**Application no: 21/CH0003/Preapp**

**Location:** Camp Road and West of Chilgrove Drive Upper Heyford

## **Transport Development Control**

TITLE
SITE ACCESS JUNCTION WITH VISIBILITY SPLAYS AND CROSSING

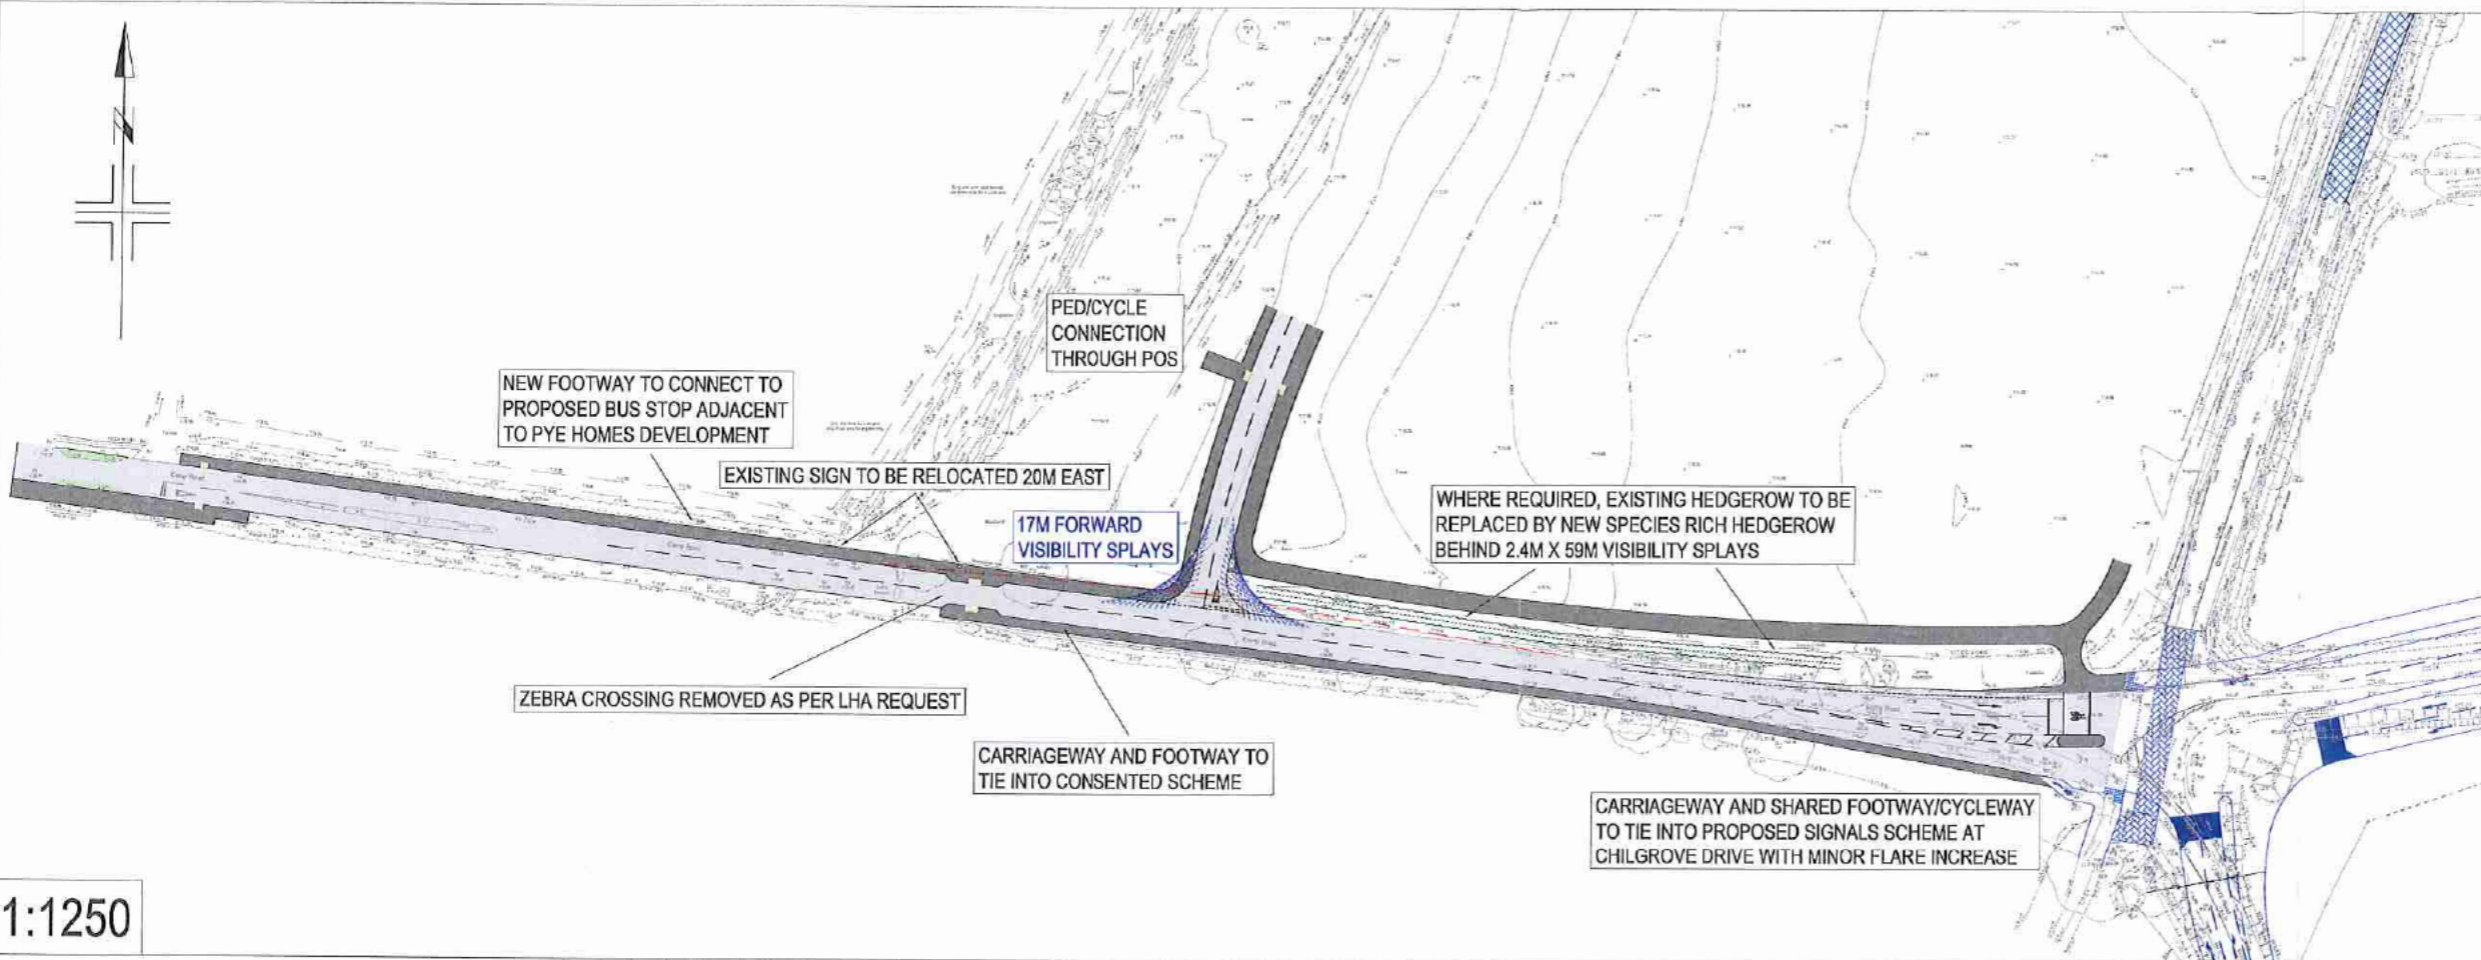
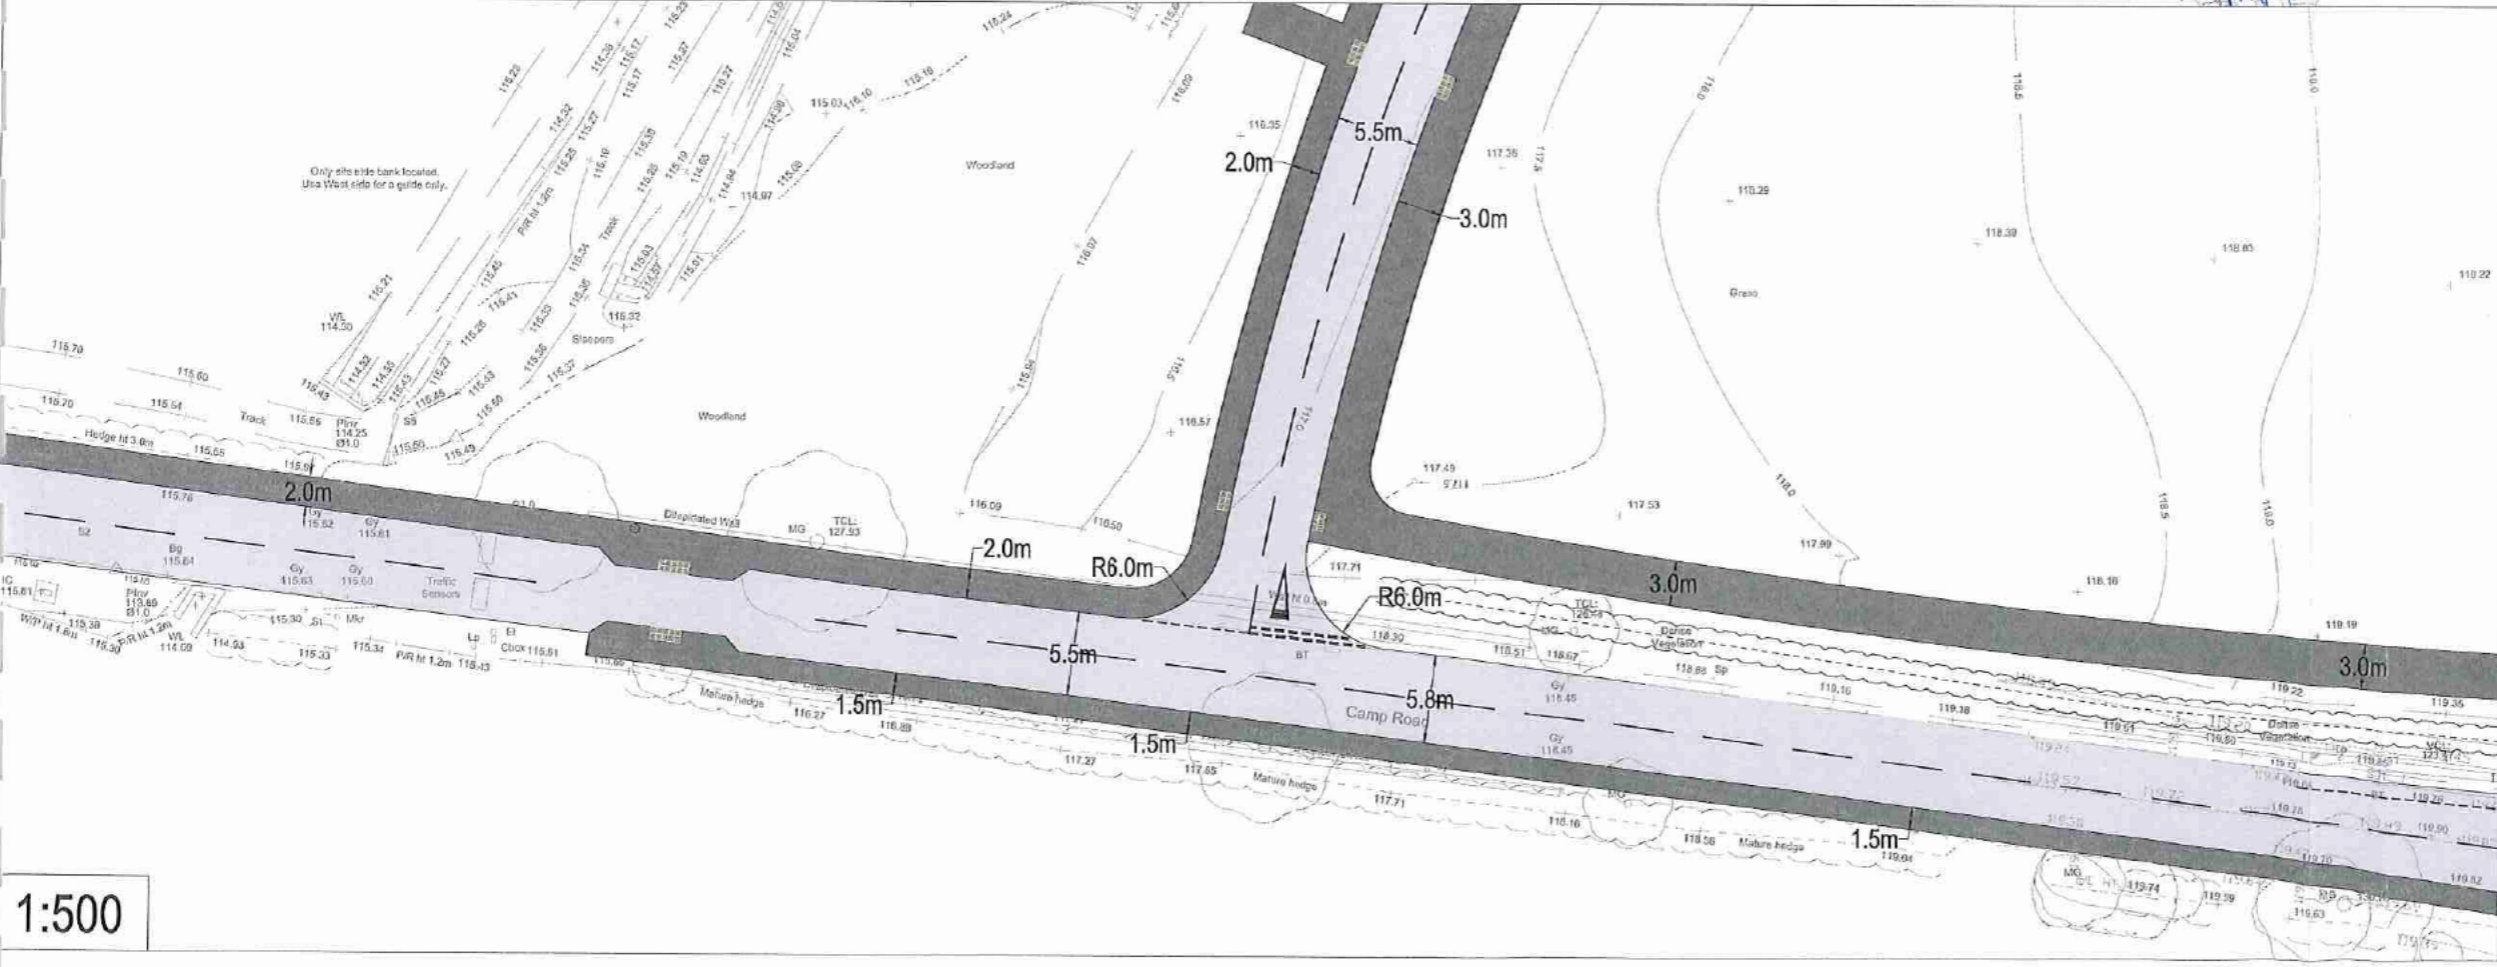
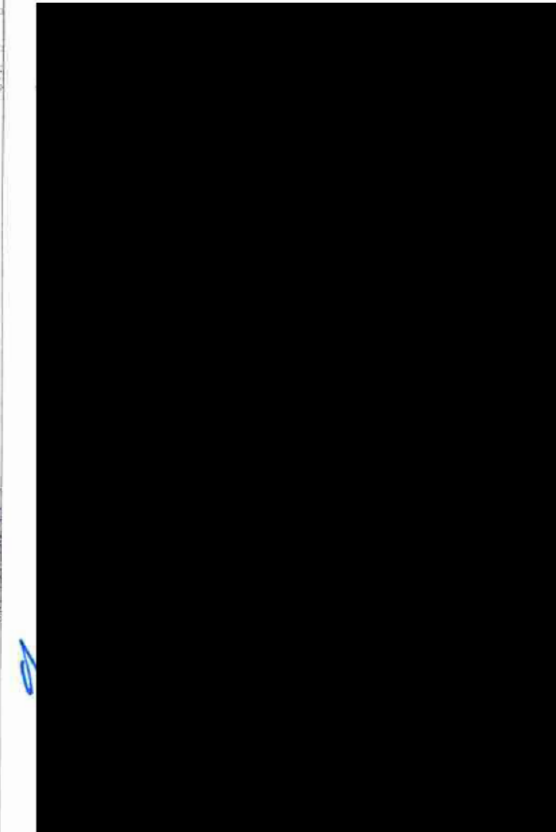
The location of the proposed access is acceptable in principle, and the County does not have concern regarding the relocation of the zebra crossing. However, this will be subject to a public consultation at the technical application stage.

The County does have concerns regarding the chicane near the signalised junction due to the possibility of vehicle queuing backing up to block the chicane. This may cause vehicles passing in the opposite direction to back up towards the junction. Pending the result of traffic modelling at this junction this aspect may require re-design.

It is recommended that the new hedgerows are replaced at a 2.0m offset from the visibility splay to allow for growth.

Pedestrian and Cycle Access Plan

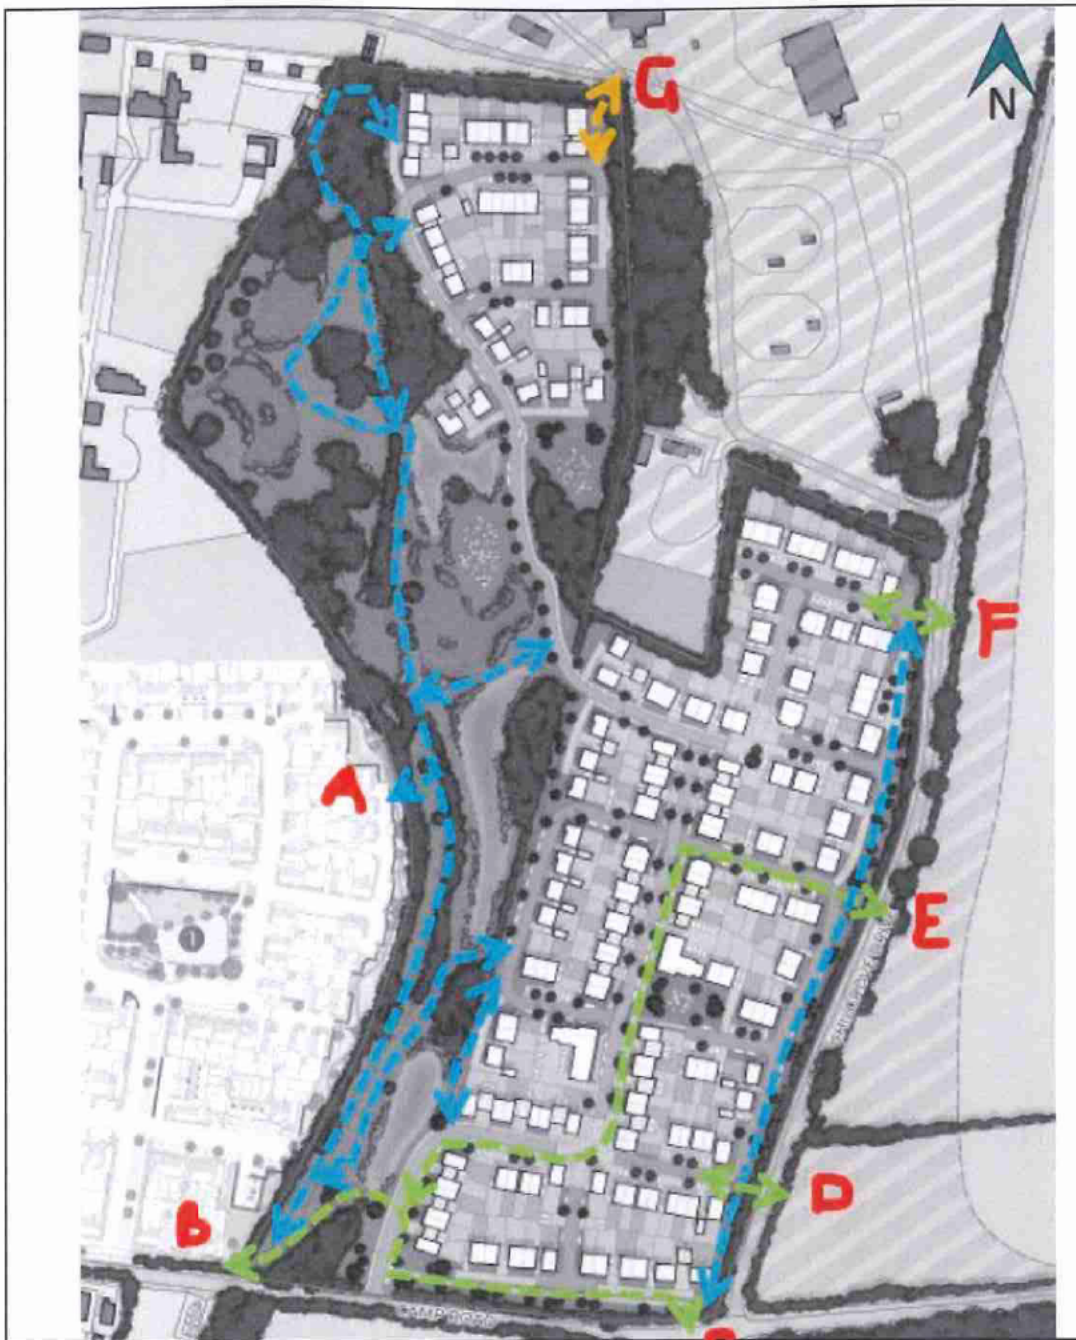
The inclusion of two proposed walking and cycling access onto Chilgrove Drive are welcomed but their location will need to be agreed. The provision of footways into Camp Road heading west is supported, but the possibility of providing a cycle path along Camp Road in some way should be explored.

The absence of a proposed walking and cycling access immediately behind the hedge across the site and to Chilgrove Drive to provide a direct route for NMUs is noted. This should be an essential component of this application going forward as it aids permeability of the site and surrounds.
